ENG-P22009-R2-TIS redlines.pdf Markup Summary

Author: Jeff Rice - EPC Engineering Review

Figure 7a

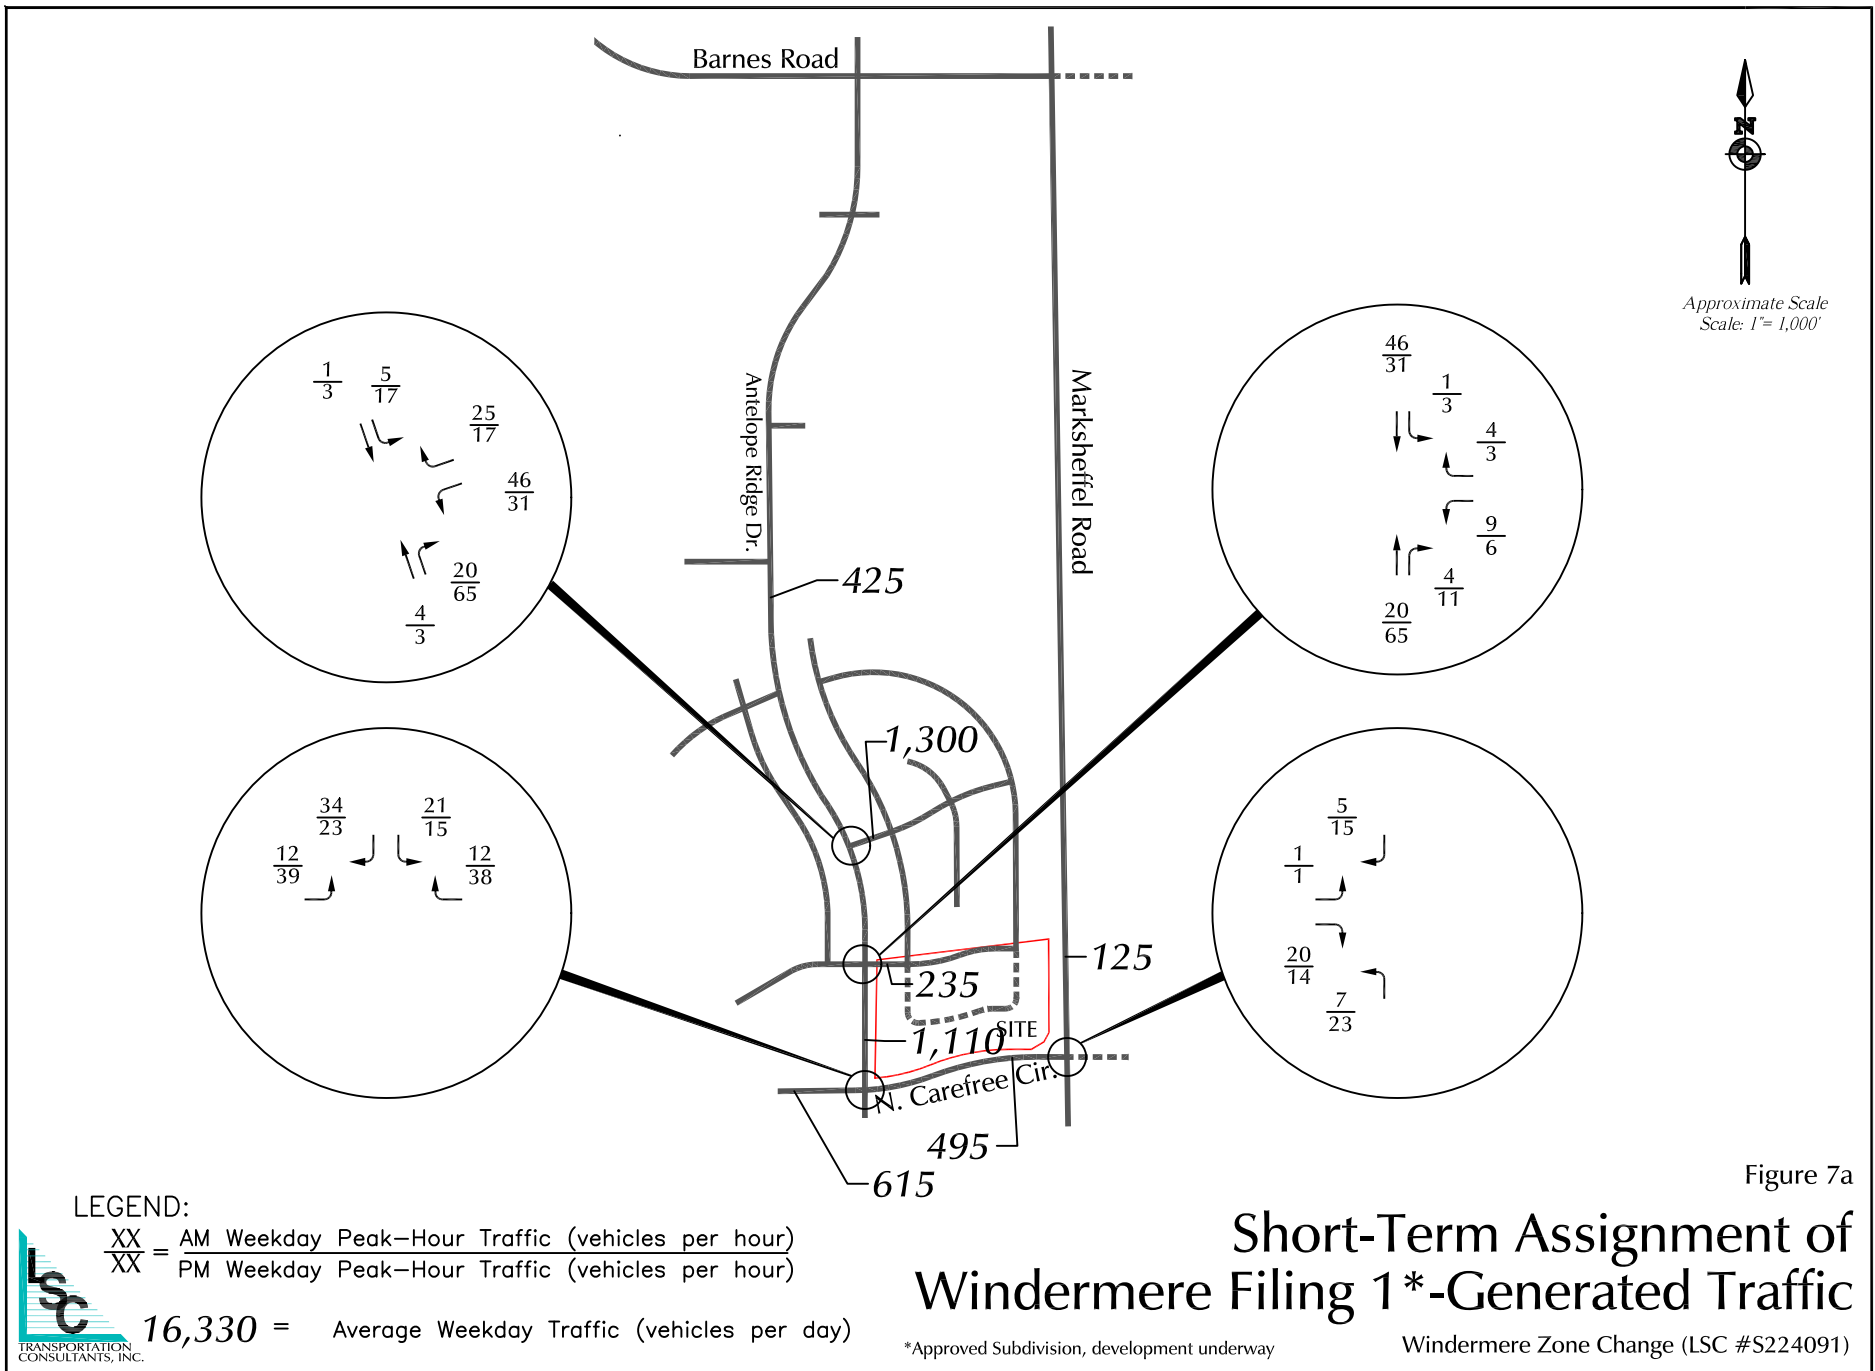
Replace or add approved trip generation for this area (40 SFD DU?) At this point Windermere Filing 1 traffic should be background (as implied by the table) and the previous study for the zone change is only informational.

Figure 9
Short-Term Total Traffic, Lane Geometry, Traffic Control and Levels of Service

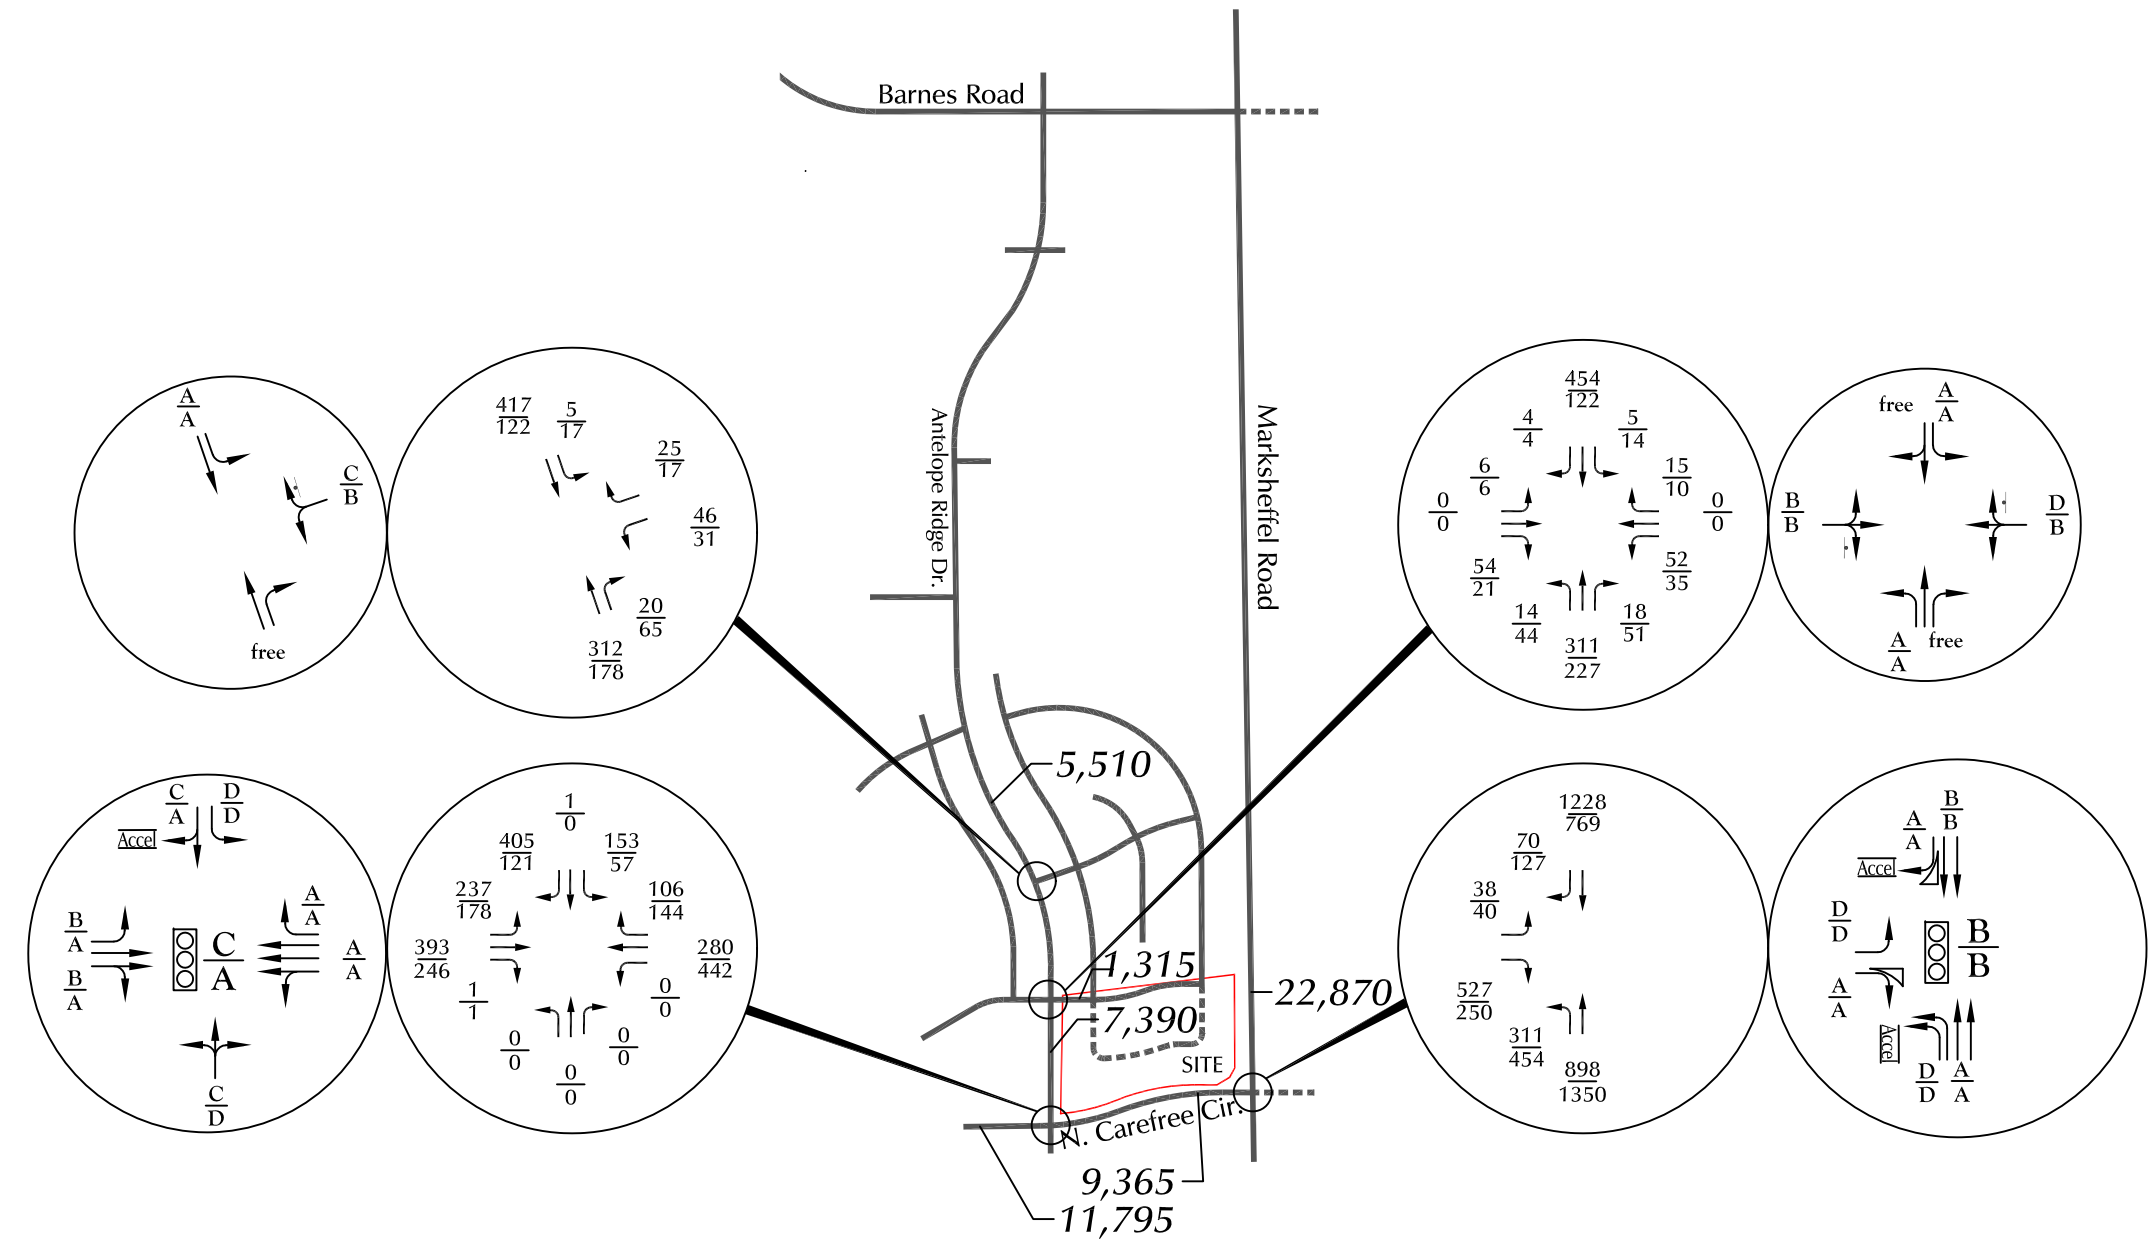
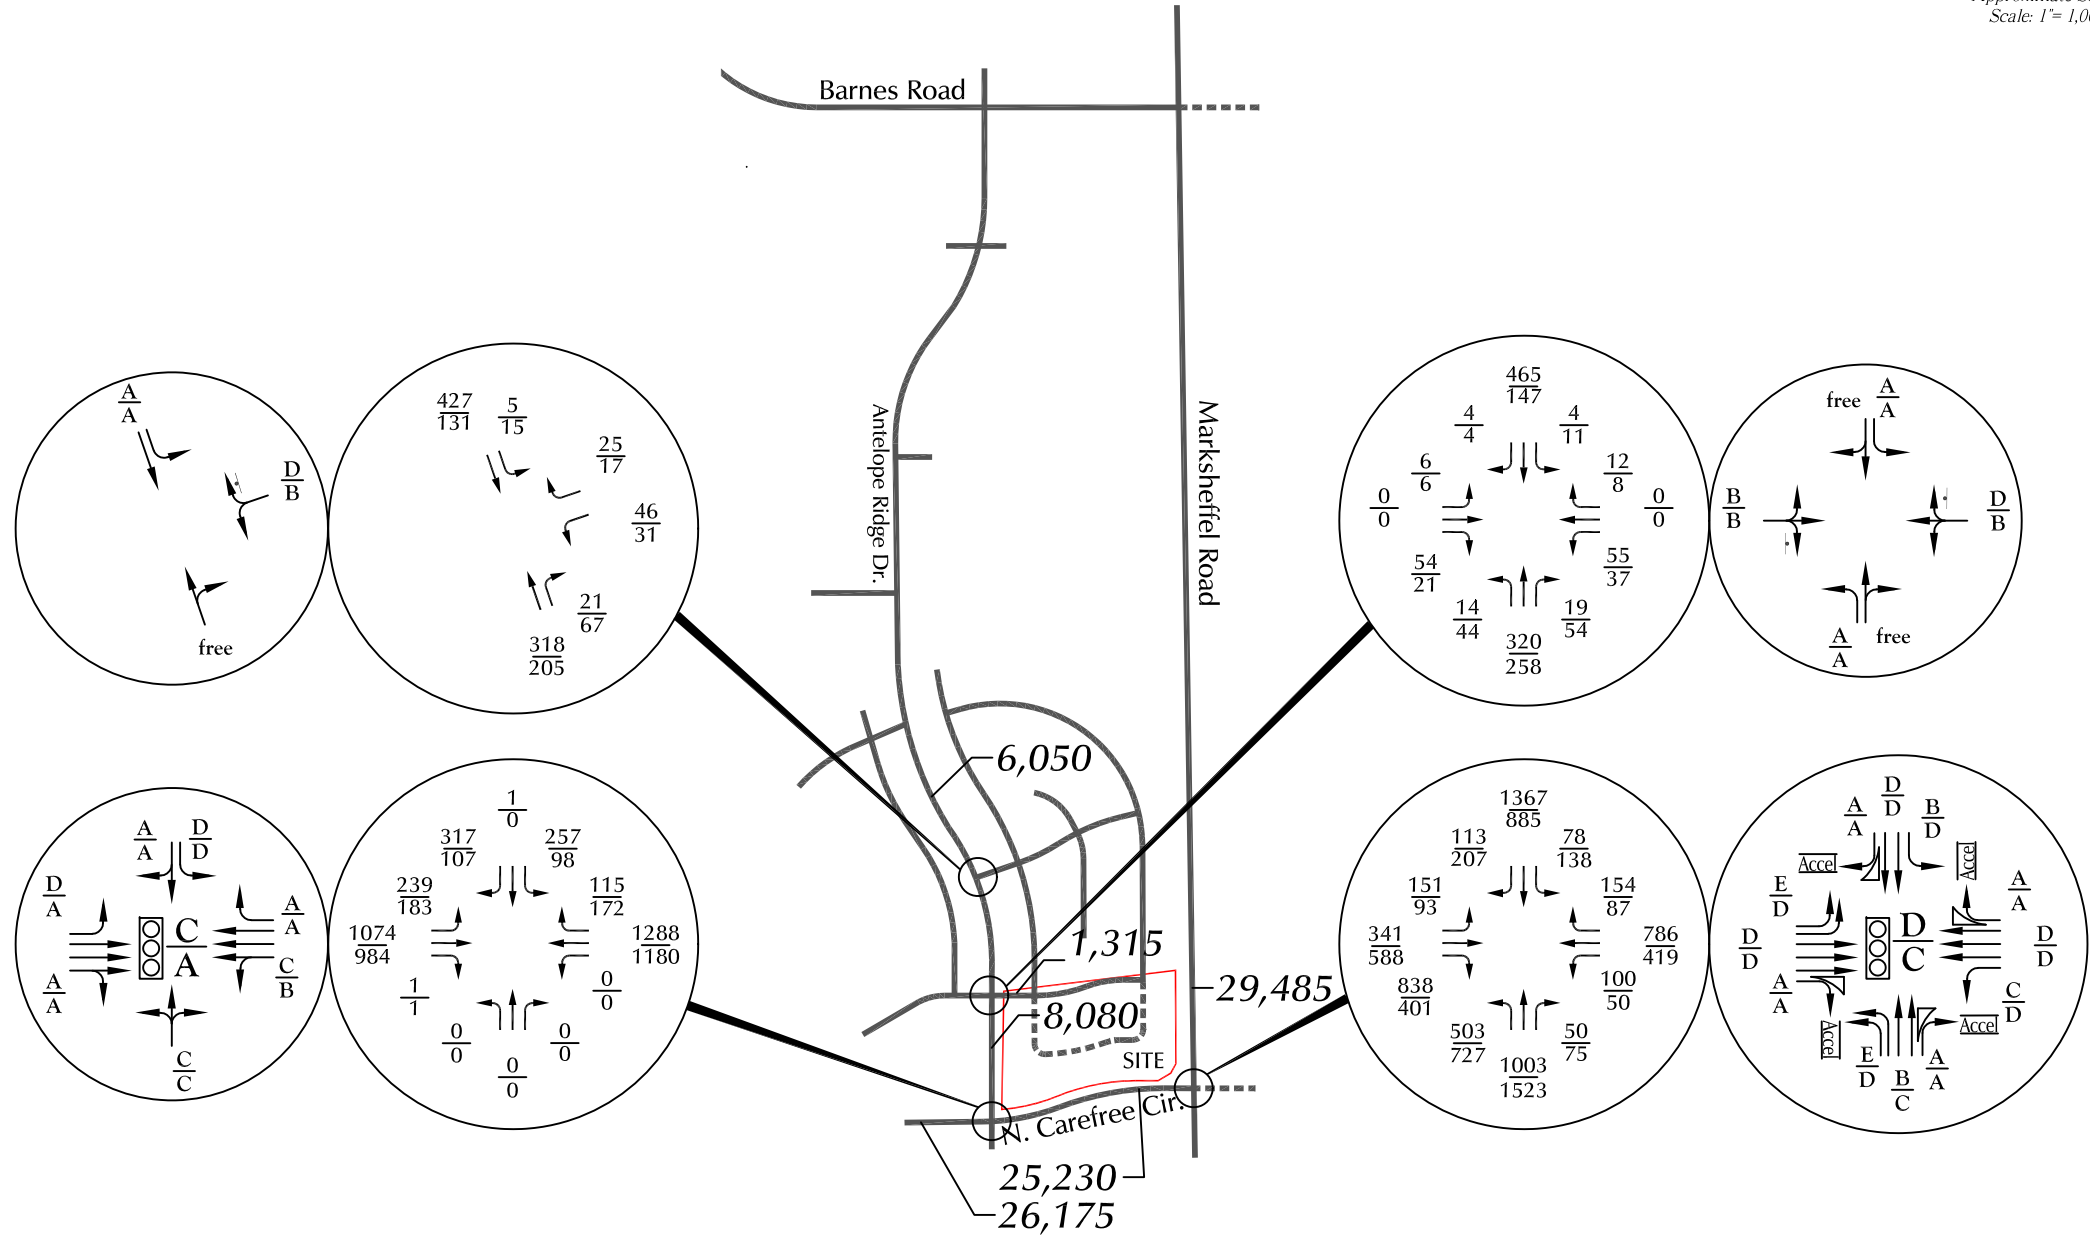
Please indicate year of short-term.

Please indicate year of short-term.
